From: [REDACTED]
To: [Sunnica Energy Farm](#)
Subject: Sunnica EN010106 - Soil Analysis
Date: 11 January 2024 10:48:33
Attachments: [Sunnica - Reading Agricultural Consultants Letter.pdf](#)

Sunnica EN010106

- The report submitted by DBSC [APP – 115 -6.2 Appendix 12B] which identifies less than 1% Best and Most Versatile land (BMV) on 924 hectares surveyed does not comply with the professional survey standards set out by the British Society of Soil Science. As the report is non-compliant its conclusions cannot be relied upon.

Sunnica Energy Farm Proposed Layout - (Predictive BMV Land Assessment)

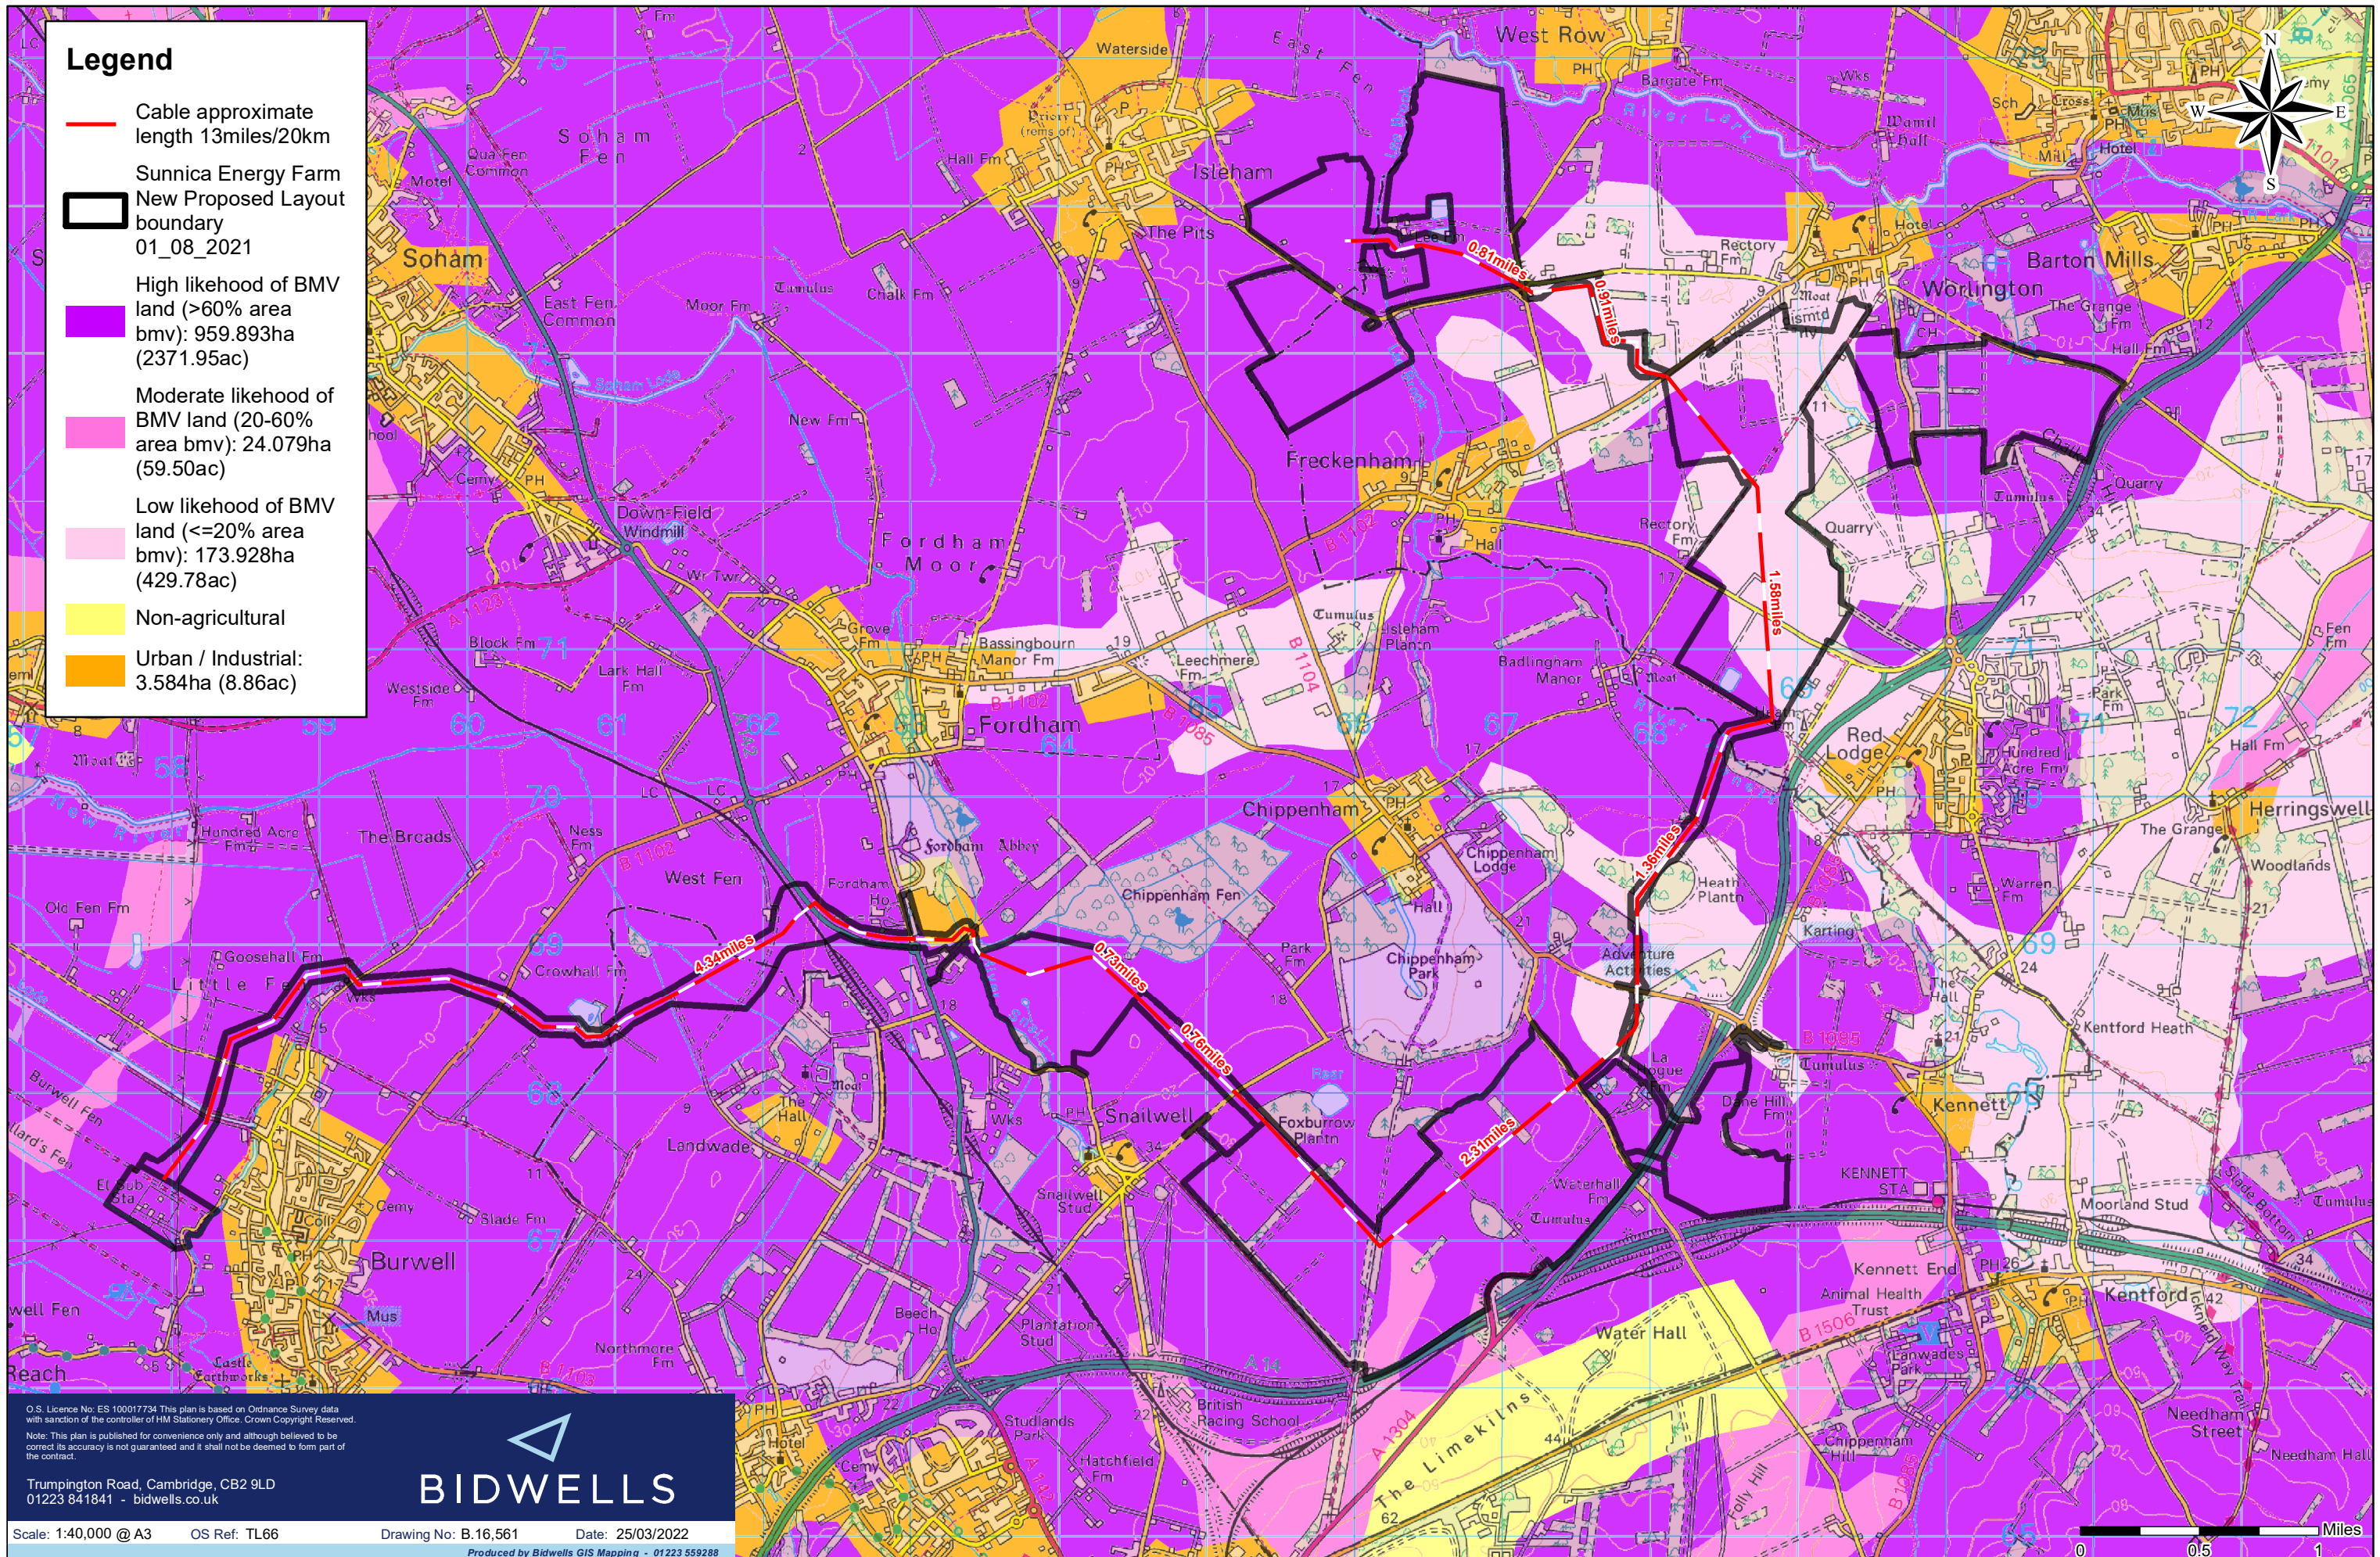
- The conclusion of the DBSC report is that only 1% of the 924 hectares surveyed is BMV. Natural England's own predictive plan (Attached as Appendix 1), based on extensive detailed mapping shows that 83% of the site is 60% or more likely to be BMV.

- On a 1,000 hectare application site it is acceptable to use the Natural England 1:250,000 scale predictive plan for soil information. Whilst this scale of mapping is inadequate for detailed interpretation on a field-by-field basis, this application extends across parishes, at which scale it is reasonable to rely on large scale mapping to provide an accurate guide to soil quality. Where Natural England's plans are showing such an extensive area of land as more likely than not to be BMV, it is extremely unlikely that a survey of 924 hectares should find only 1% BMV.

- The point above is also relevant to Natural England's criticism of the use of the 1:250,000 provisional ALC map across a large area. See the map attached at appendix 3 which shows at least 50% of the site to be BMV on the assumption that the grade 3 land in East A is all 3a and the remainder of the land graded 3 is 50% grade 3a and 50% grade 3b. With the size of Sunnica it is acceptable to use this plan to identify BMV.
